Our ref: HA/2015/116863/01-L01
Your ref: LU/71/15/PL
Date: 06 May 2015

**CONVERSION OF GROUND & FIRST FLOOR AT THE REAR INTO TWO 2
BEDROOM FLATS**

10 ST CATHERINES ROAD LITTLEHAMPTON BN17 5HS

Environment Agency position

NEW GROUND FLOOR PLAN AND FLAT 1

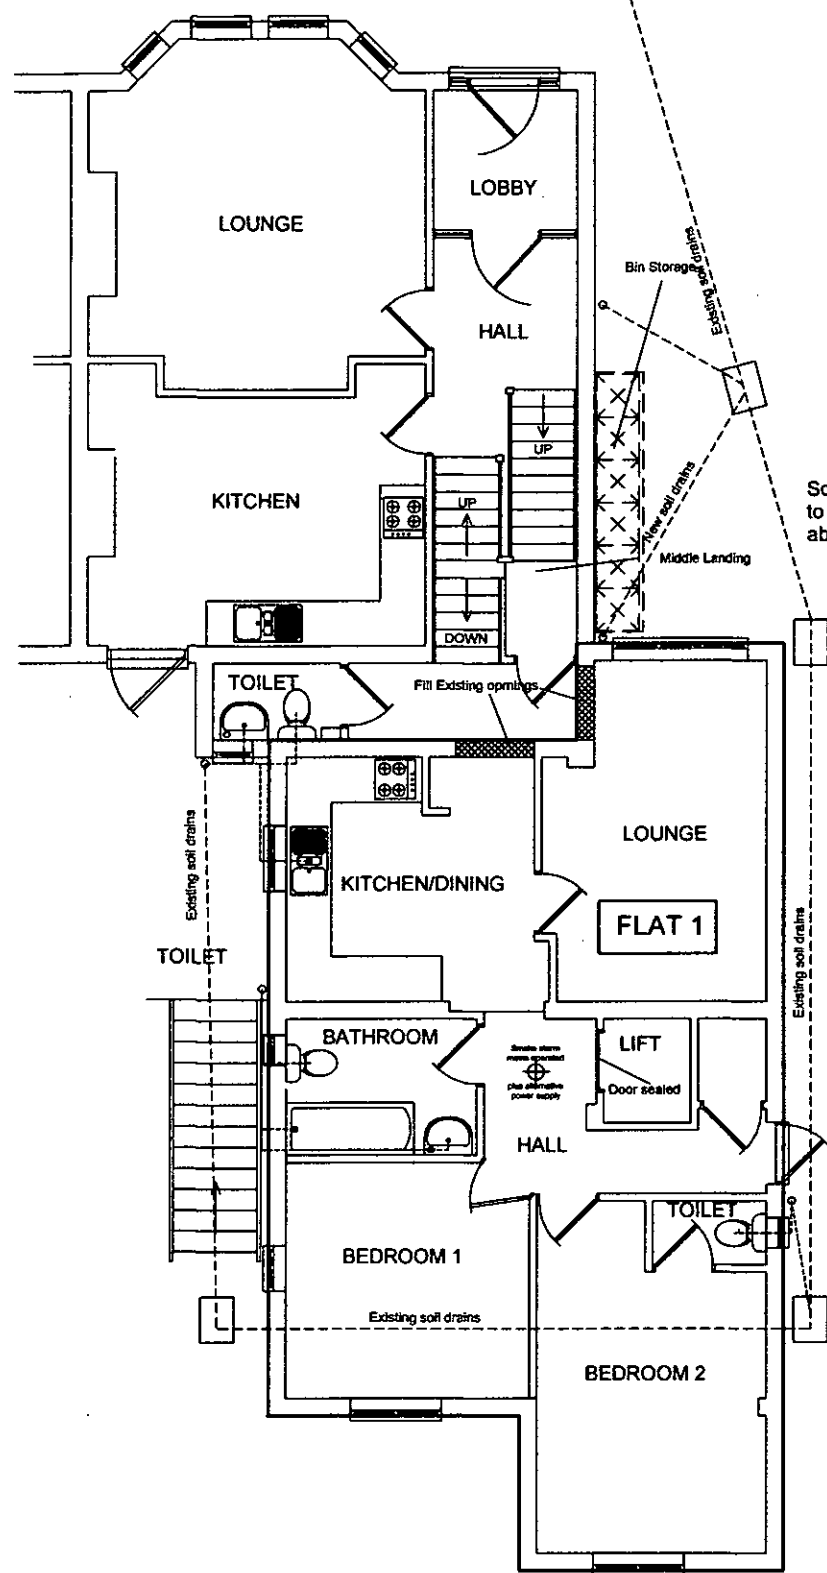
The application site is shown to be within flood zone 3, a high flood risk area in accordance with the National Planning Policy Framework (NPPF). There is the potential for flood depths of over 1 meter therefore we would consider that sleeping accommodation on the ground floor with no access to the first floor may pose an unacceptable risk to occupants in accordance with Table 13.1 of the Defra / Environment Agency Flood and Coastal Defence R&D Technical Report FD2320/TR1.
